DRB Application No.: 07DRB-70144 (P&F)

Project Name: MAYFLOWER HEIGHTS

**CITY OF ALBUQUERQUE
PLANNING DEPARTMENT
August 1, 2007
DRB Comments**

RE: Lots 1, 2, 3 , Block 3, Mayflower Heights/minor plat

PLAT OF
LOT 1-A & 2-A, BLOCK 2
 BEING A REPLAT OF LOT-1, LOT-2 & EAST 50' OF LOT-3, BLOCK 2
MAYFLOWER HEIGHTS SUBDIVISION
 ALBUQUERQUE, BERNALILLO COUNTY, NEW MEXICO
 APRIL, 2007

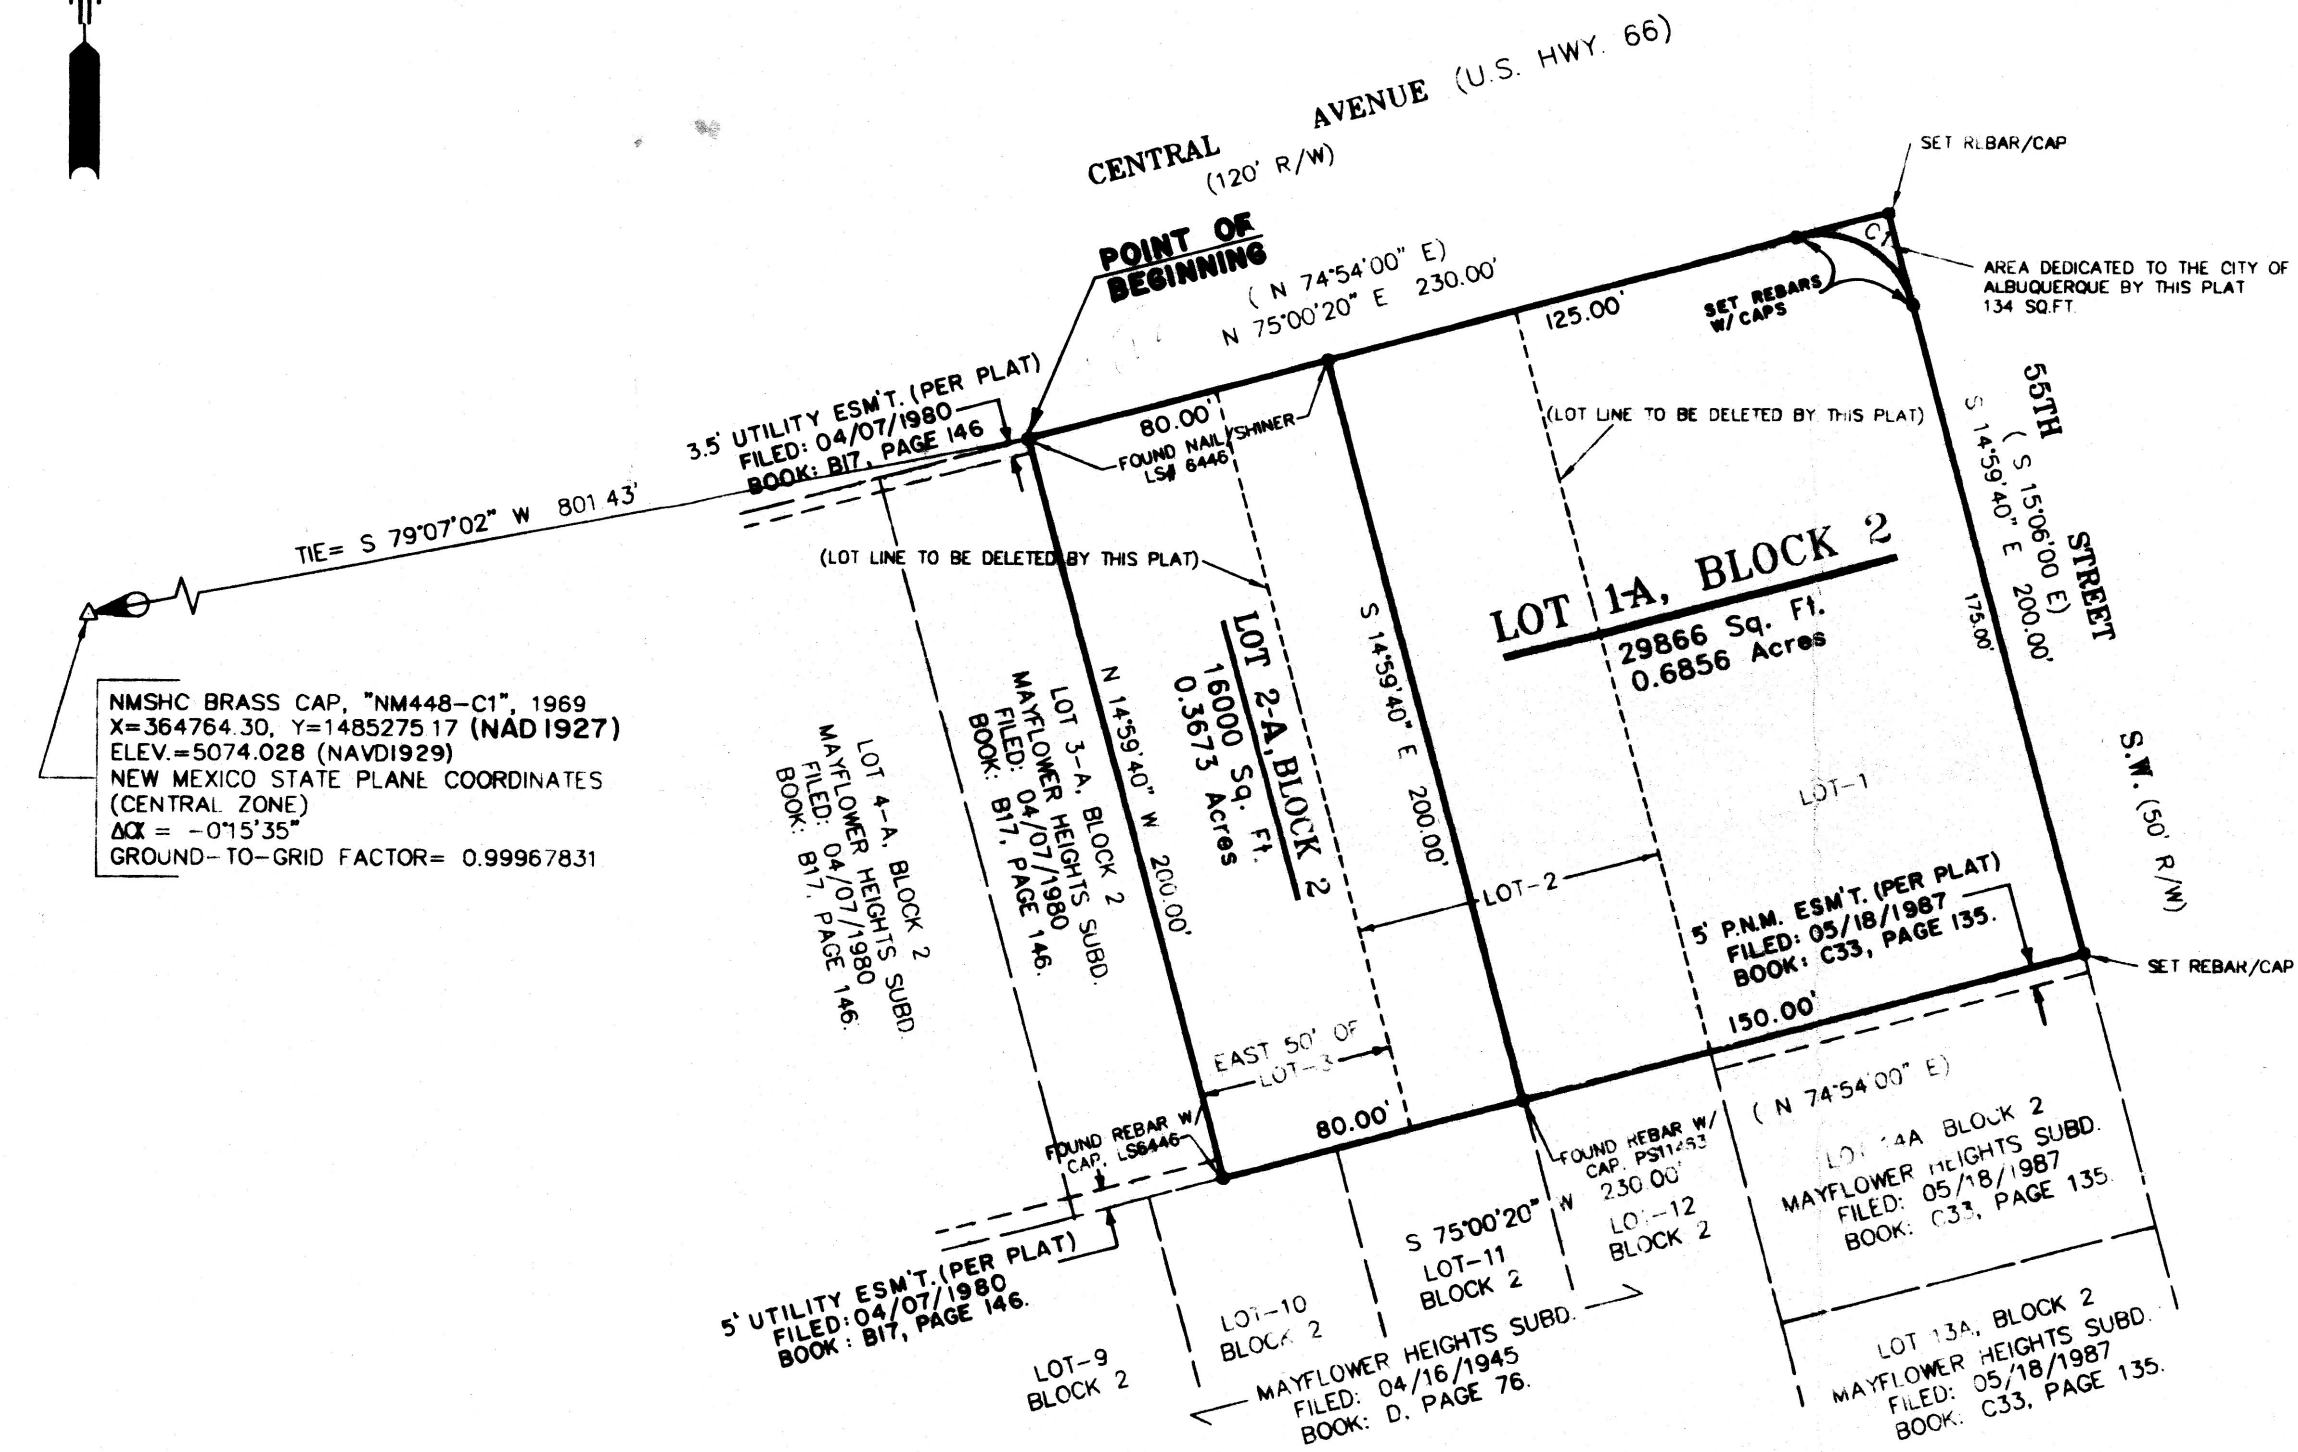
What happens to the remainder of Lot 3?

| <u>No.</u> | <u>Comment</u> |
|------------|---|
| 1) | What are the widths of the sidewalks along Central and 55 th Street? |
| 2) | What are the distances from face of curb to the property lines along Central and 55 th Street? |

SITE SKETCH OF
LOT 1A & 2A, BLOCK 2
 BEING A REPLAT OF LOT-1, LOT-2 & EAST 50' OF LOT-3, BLOCK 2
MAYFLOWER HEIGHTS SUBDIVISION
 ALBUQUERQUE, BERNALILLO COUNTY, NEW MEXICO
 APRIL, 2007

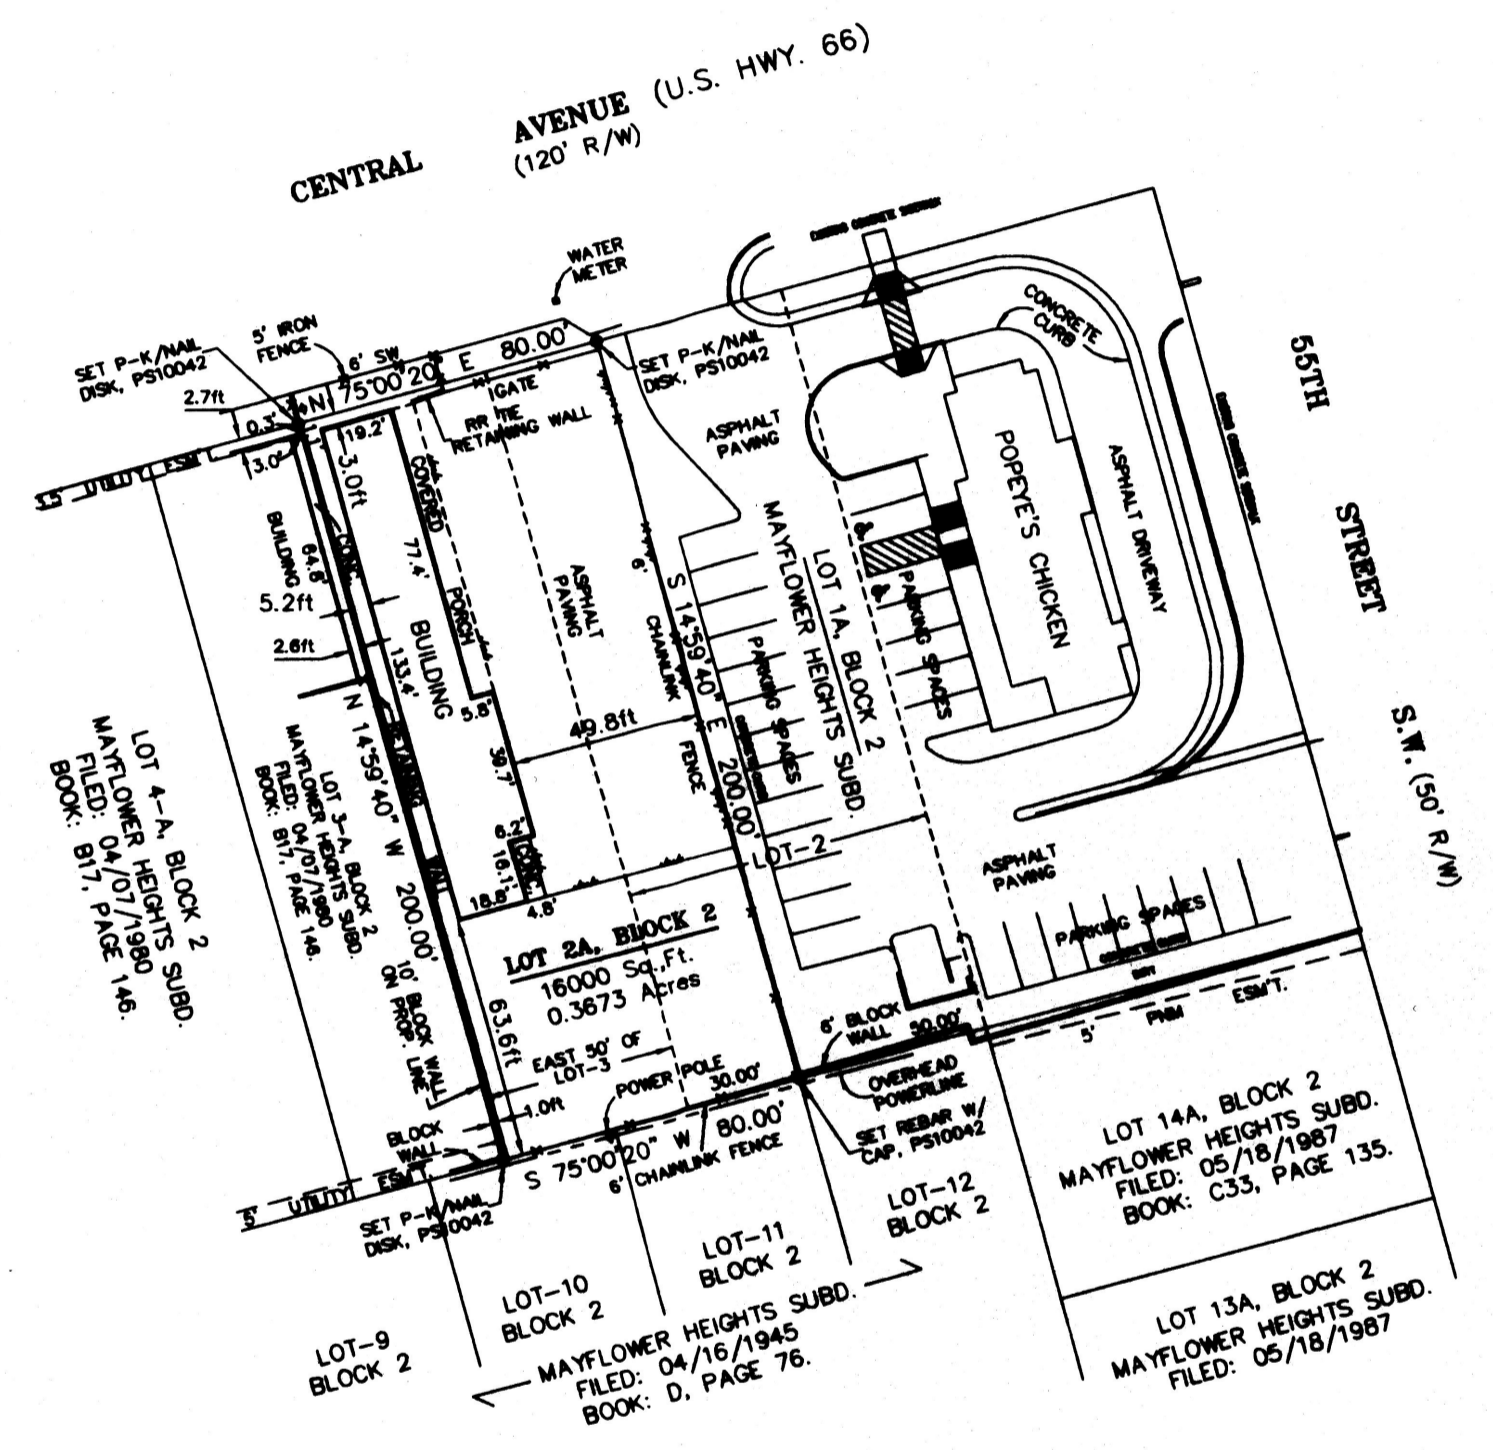
Are both lots already developed?
